Preferred Project Report

Discovery Point, 1 Princes Highway, Wollongong Stage 1 Mixed Use Development (MP10_0030)

Submitted to Department of Planning & Infrastructure
On Behalf of Discovery Point Pty Ltd

November 2011 ■ 10619

Scale	1:500 @ A1 1:1000 @ A3
Drawn	APW
Checked	MA
Project No.	S11191
Status	PLANNING
Plot Date	18/4/2011 12:00:46 PM
Plot File	S:\11100-11199\11191_australand_wollicreek\00_maintrans\02 ...
Drawing No.	DA3-001
Revision	E

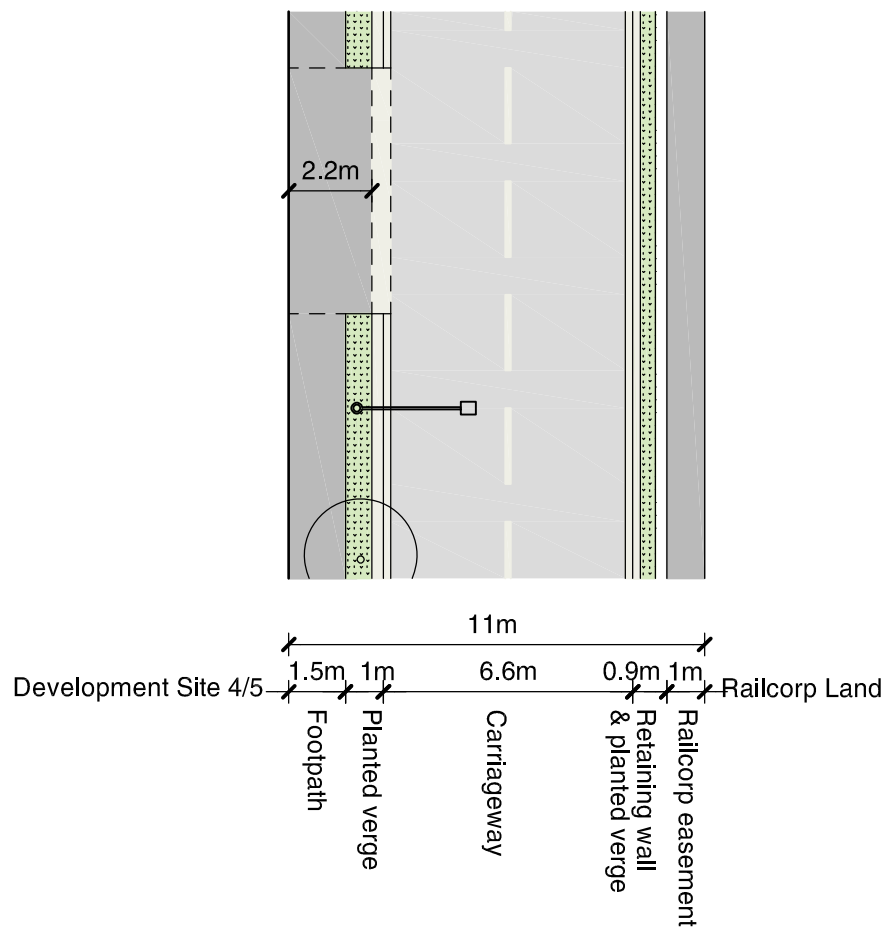
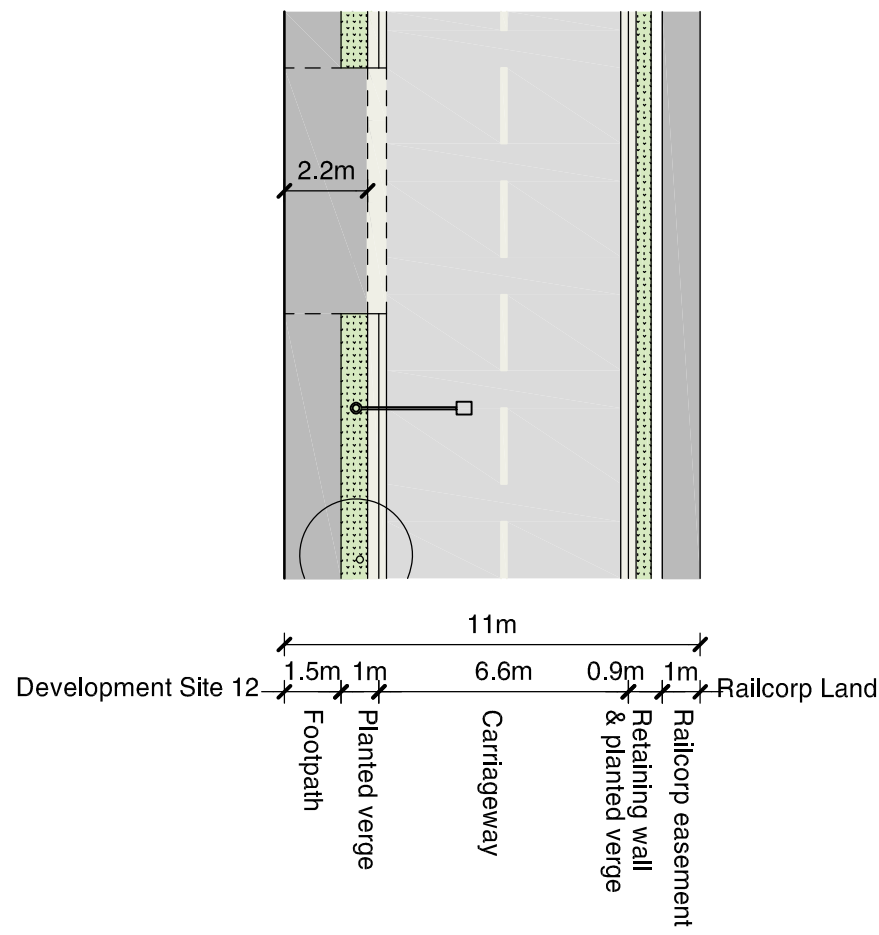
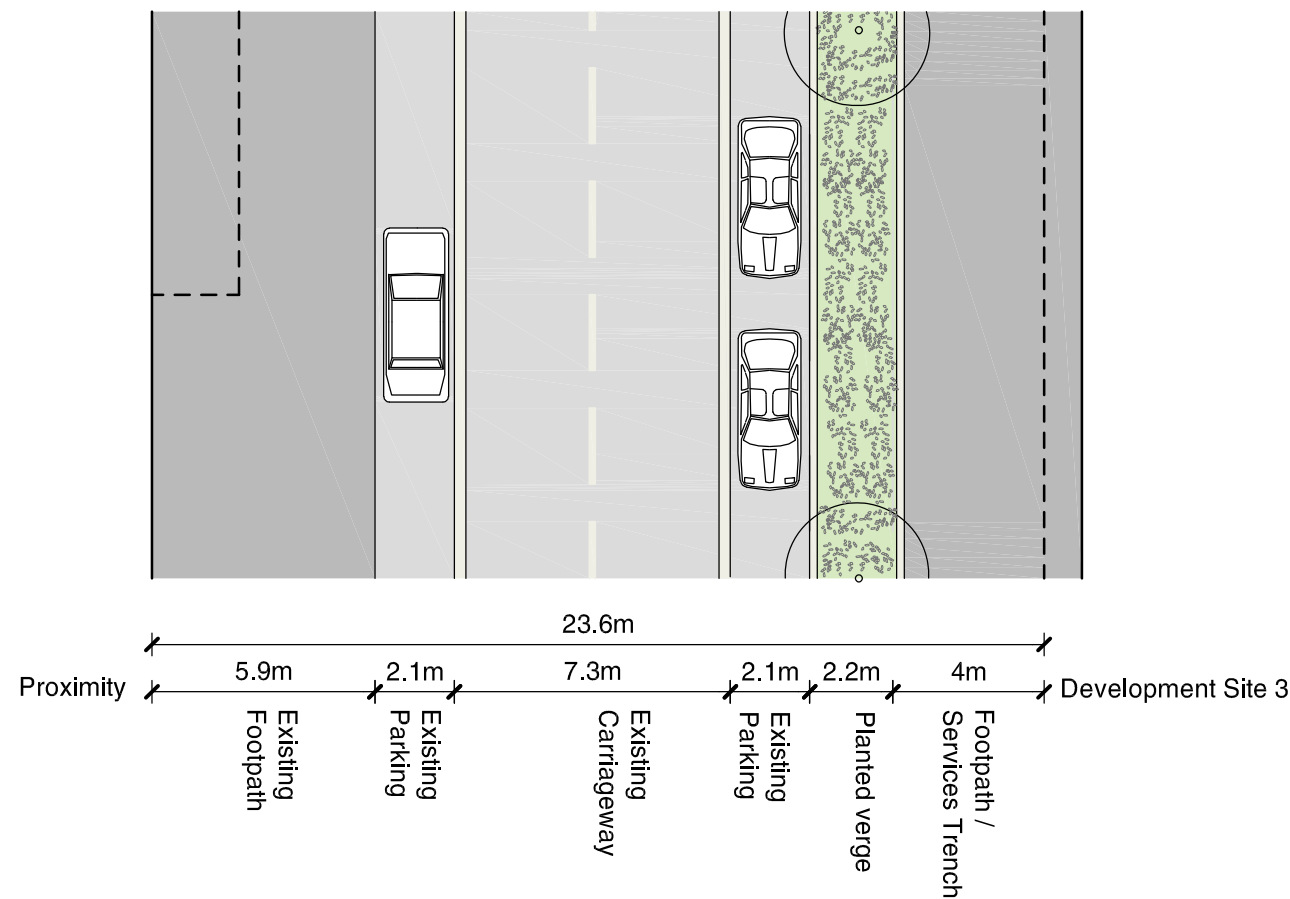
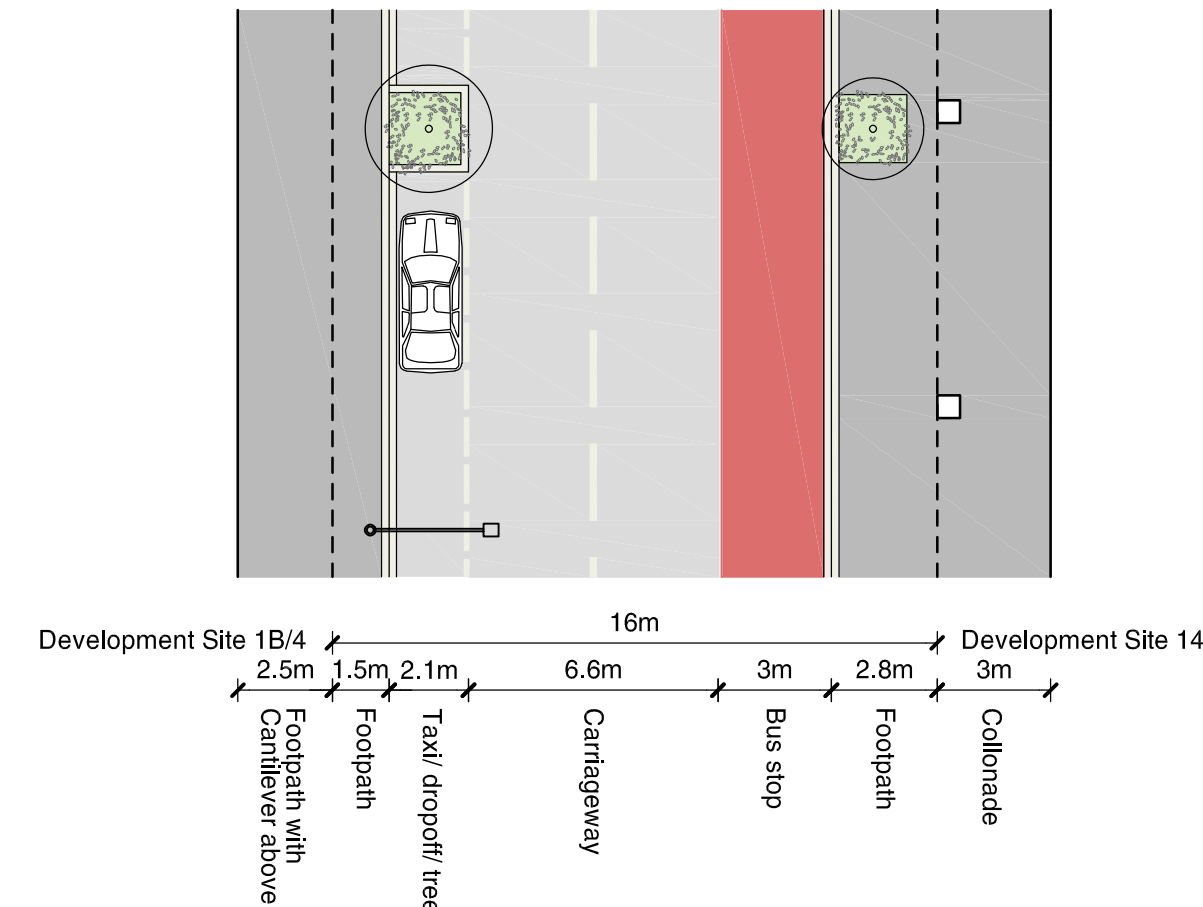
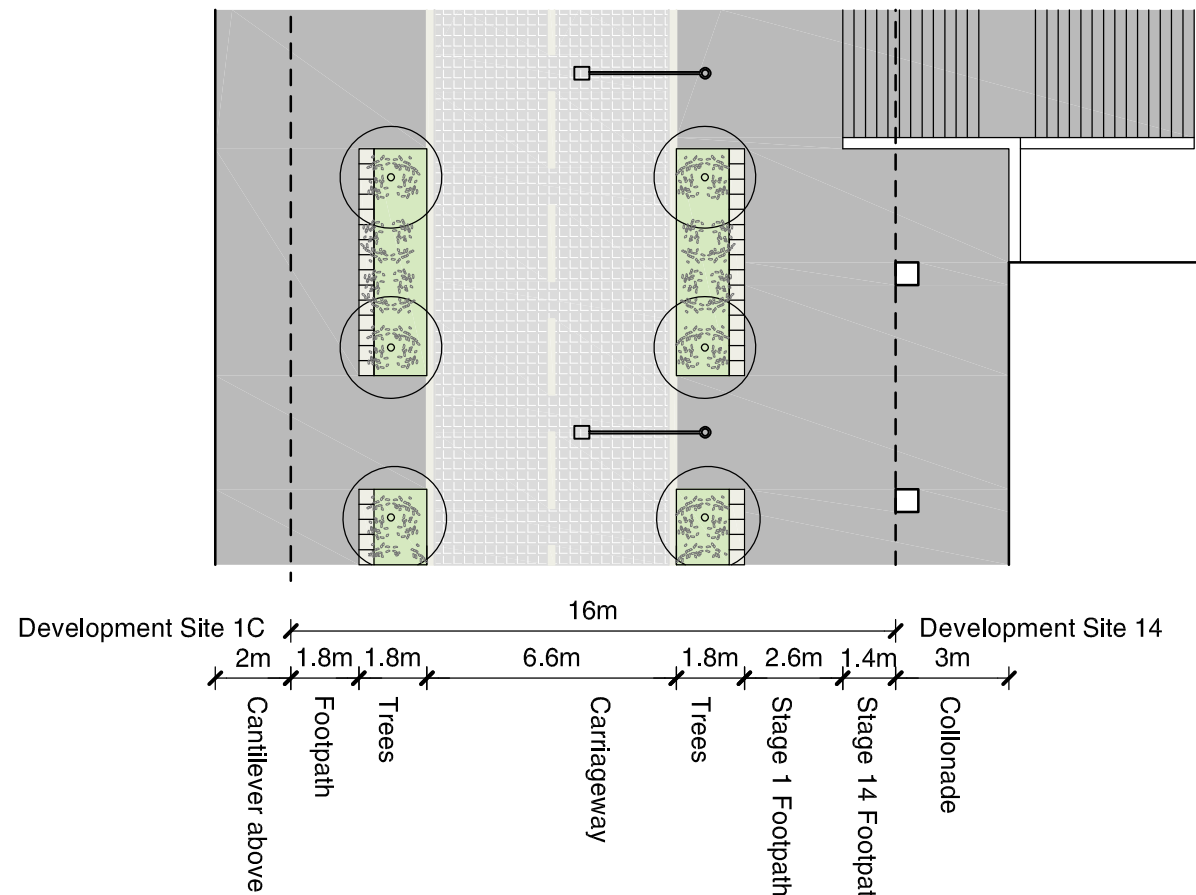
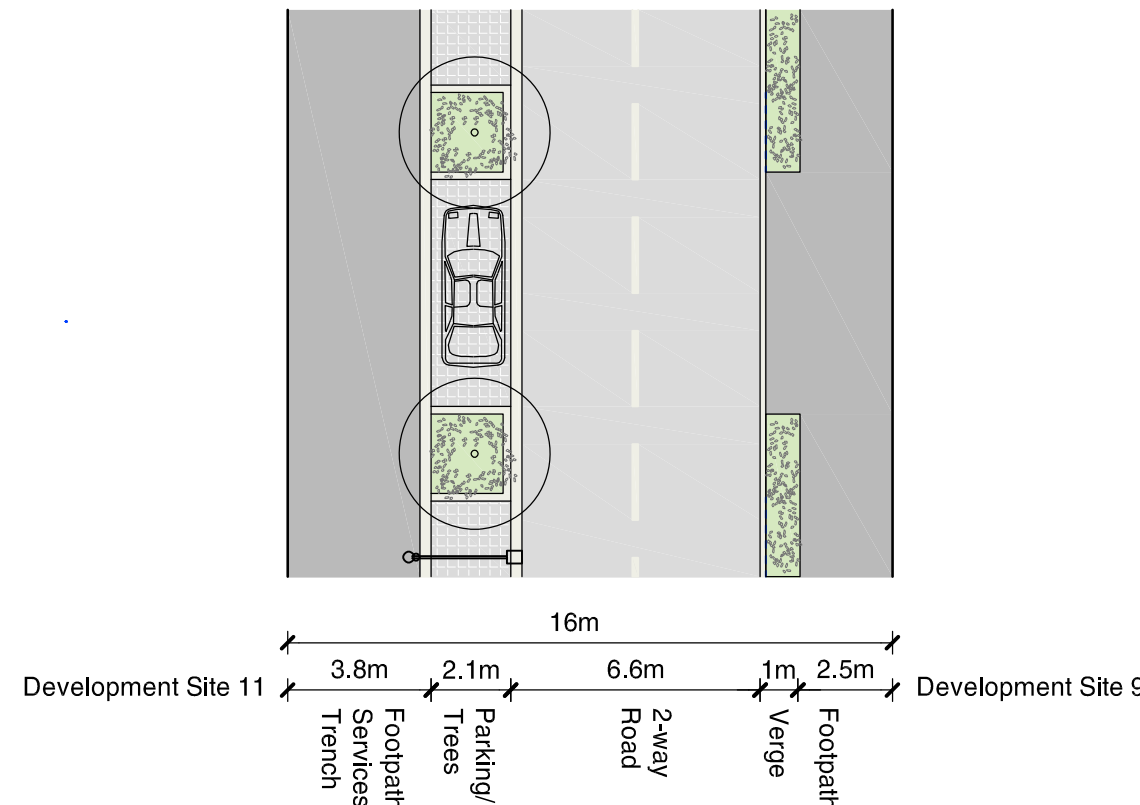
- *further details and plans be submitted to demonstrate that the development will result in a building separation along the length of Discovery Point Place of a minimum of 16 metres (not including colonnades) in accordance with Modification B1 of the Concept Plan Approval;*
- *dimensions of balconies be indicated on the plans to ensure compliance with Requirement A10 of the Concept Plan Approval; and*
- *clarification be provided that the Development Design Guidelines have been amended to address plant rooms and lift overruns on the roof being appropriately screened and not to exceed approved heights as required by Modification B3 (h) of the Concept Plan Approval.*

In accordance with Modification Condition B1 of the Concept Plan Approval, Building 14 has been reduced in width in order to provide a building separation along the entire length of Discovery Point Place of 16m. The revised building envelopes drawing (DA3-001 Rev E) is included at **Appendix F**. As a flow on to updating this plan, the approved Street Setout plan (Drawing DA3-101) has also been amended to ensure building separation distances are correct. This plan has also been updated in order to achieve compliance with AUSTROADS (which is a requirement of the Concept Plan approval). A copy of the revised Drawing DA3-101 (Rev H) is included at **Appendix F**.
